HYNET CARBON DIOXIDE PIPELINE

Development Consent Order

Response to Examining Authority

Ref: JB.SC.CPT3510

EN070007-D.2.2-LP-Sheet 20

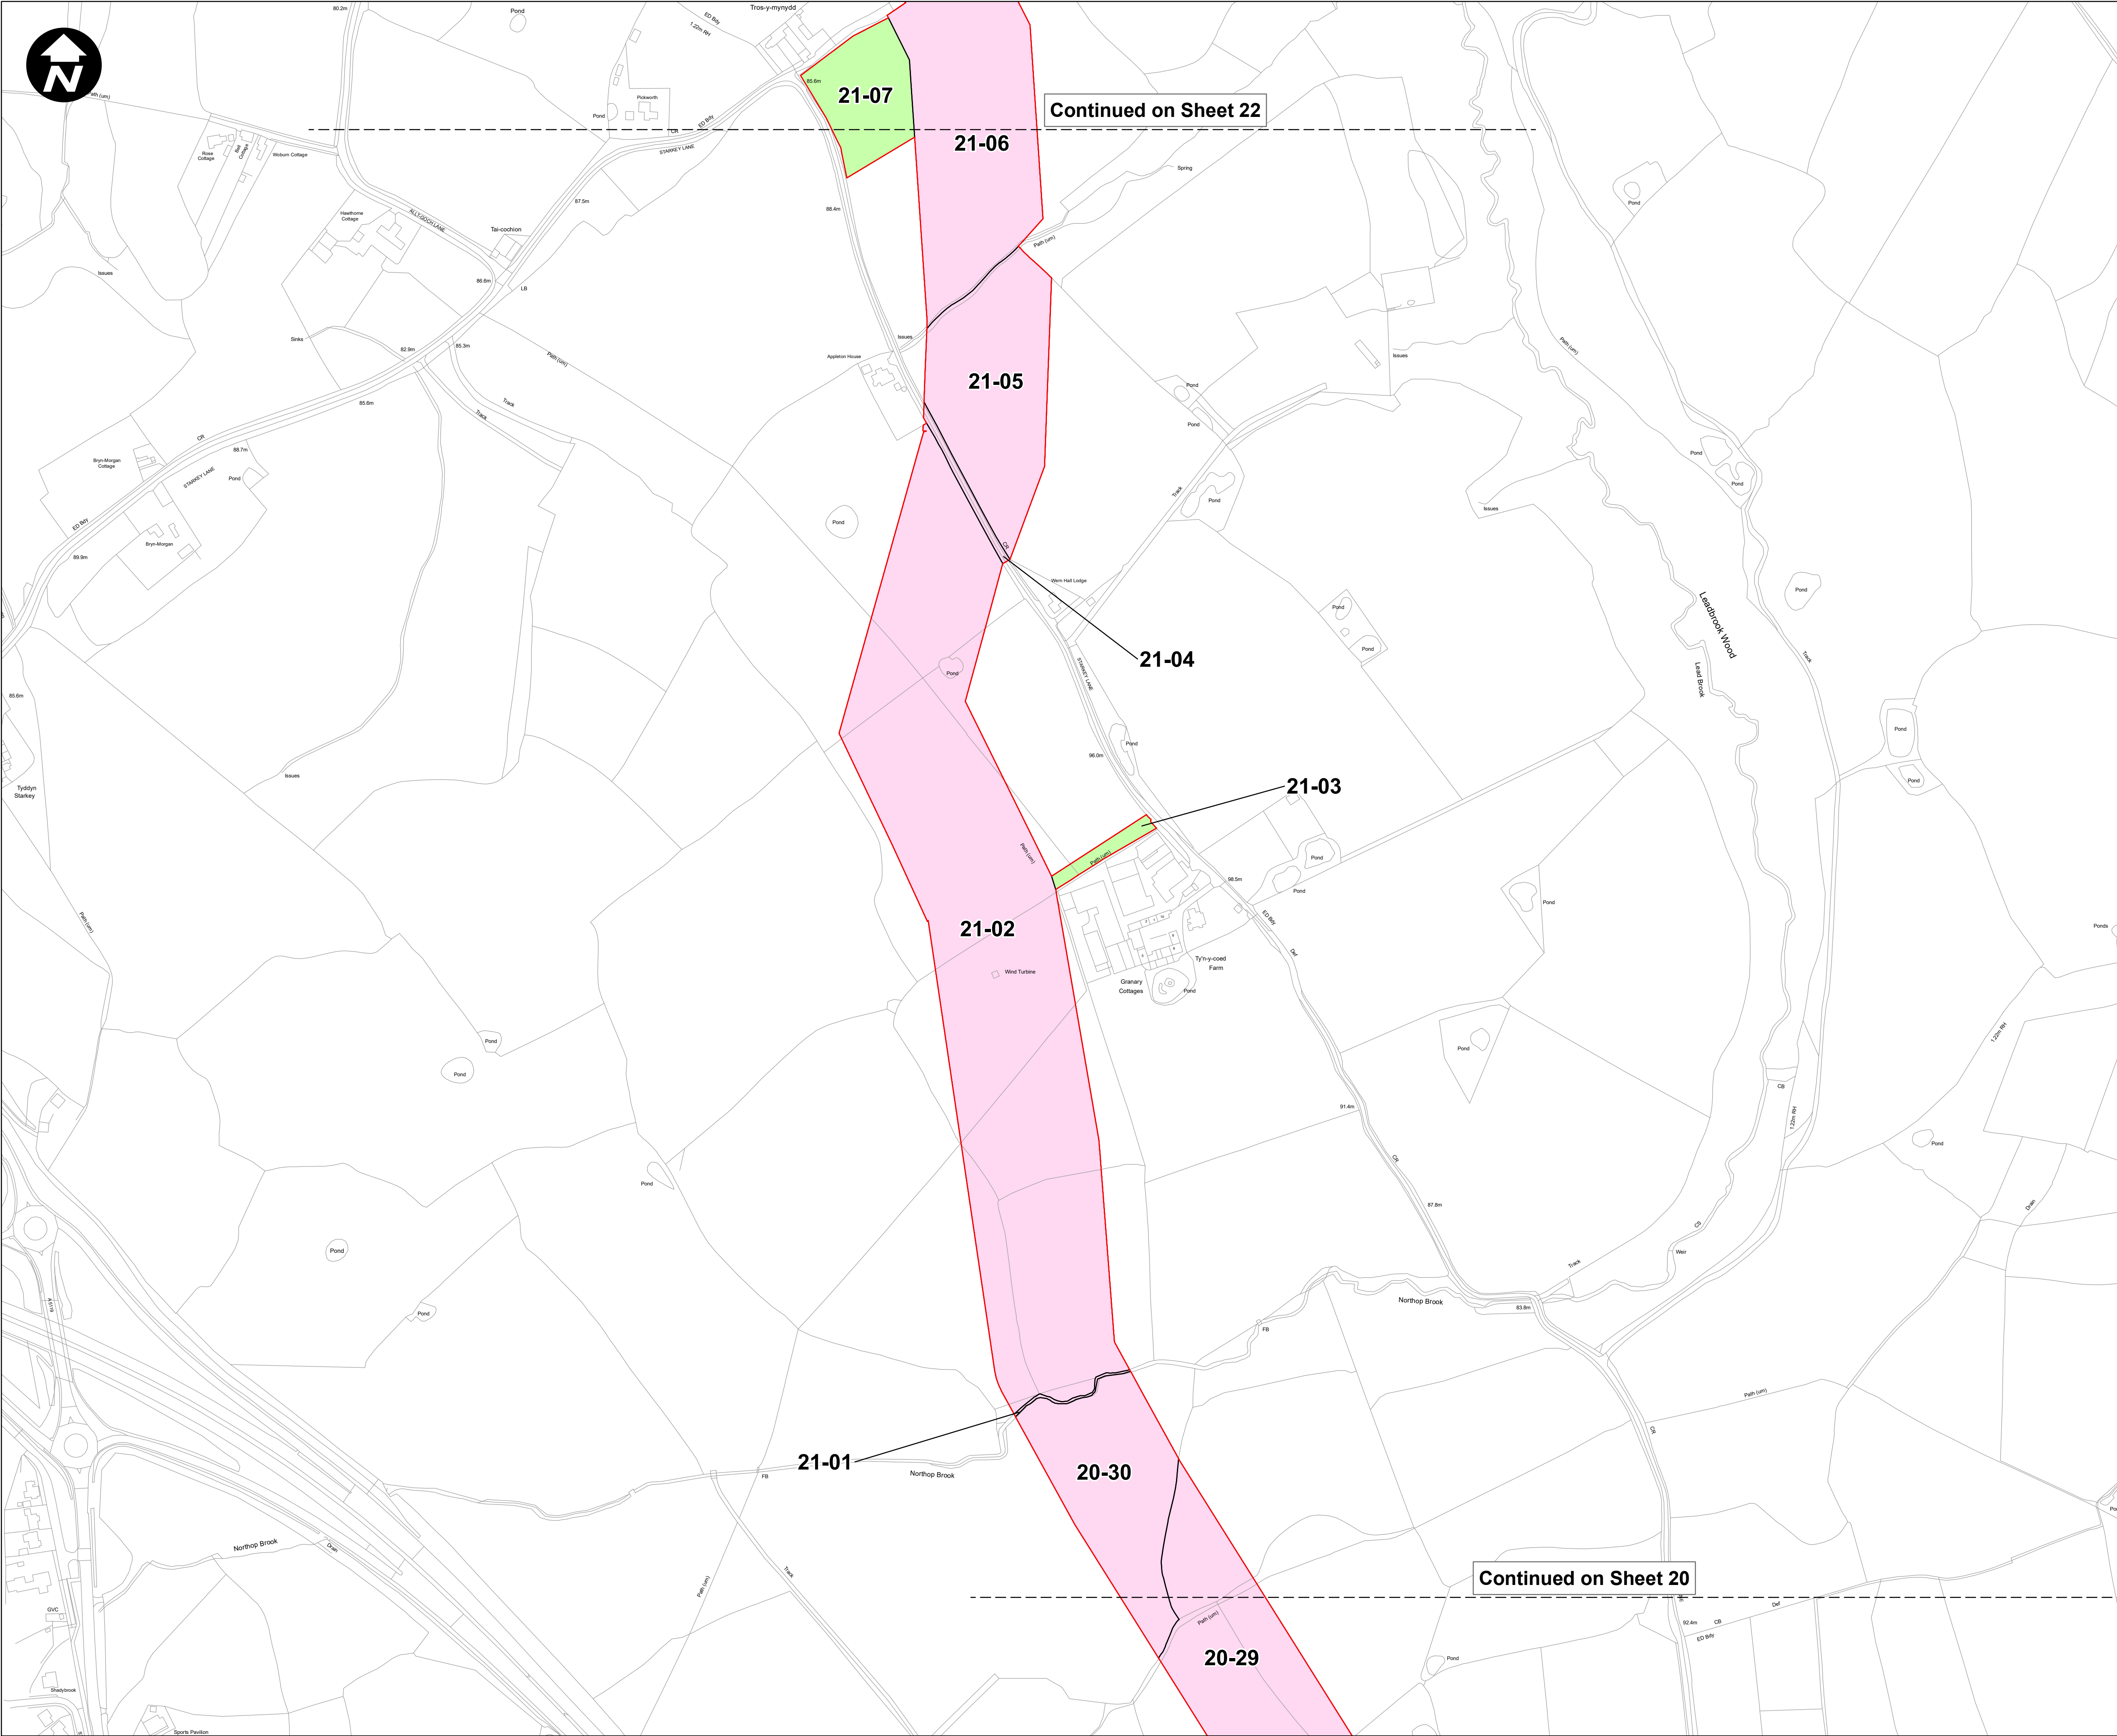
The route of the pipeline passes through the middle of all fields on the block of land and will affectively remove this area from the farm which totals 44 acres. We have requested that the developer seek to move the pipeline to the northern or southern boundary of the property, and its location to the southern boundary would greatly mitigate the impact on the land.

The land is affected, not just by the construction of the pipeline but also a large construction compound for the construction of the Northrop Hall AGI. It is an accepted principle that large scale excavations, including the separation and replacement of topsoil from subsoil has a significant impact upon the productive capacity in yield potentials over agricultural land following the reinstatement of the land post works, even in ideal weather conditions. When conditions are less variable, particularly during periods of extremely wet weather, as we are

now prone to suffer, the use of heavy planting and construction equipment across agricultural land during the works and during its reinstatement will cause long lasting or in a worse case scenario, repair damage to the soil structure, particularly if the soil becomes mixed with the topsoil. This damage could be mitigated by ensuring that the developer limits excavation works to summery months and that works are delayed when periods of heavy rain are forecast, and we would request that the examining authority apply such conditions along the length of the route.

Given the presence of the AGI, major construction compound and a significant length of pipeline affecting this land, we are extremely concerned that the damage to the soil structure and run off from the AGI site will cause flooding and water logging to the land. A culvert underneath the A55 has been identified as an outlet for such water and we have requested that the Developer carry out detailed drainage surveys, however unfortunately we have not received any response from Hynet on this issue. The Bletcher's are extremely concerned that should drainage issues and flooding continue to affect the land post construction, it will effectively reduce the forage producing capability of the holding which will have a knock on effect on cow numbers and in turn, profitability.
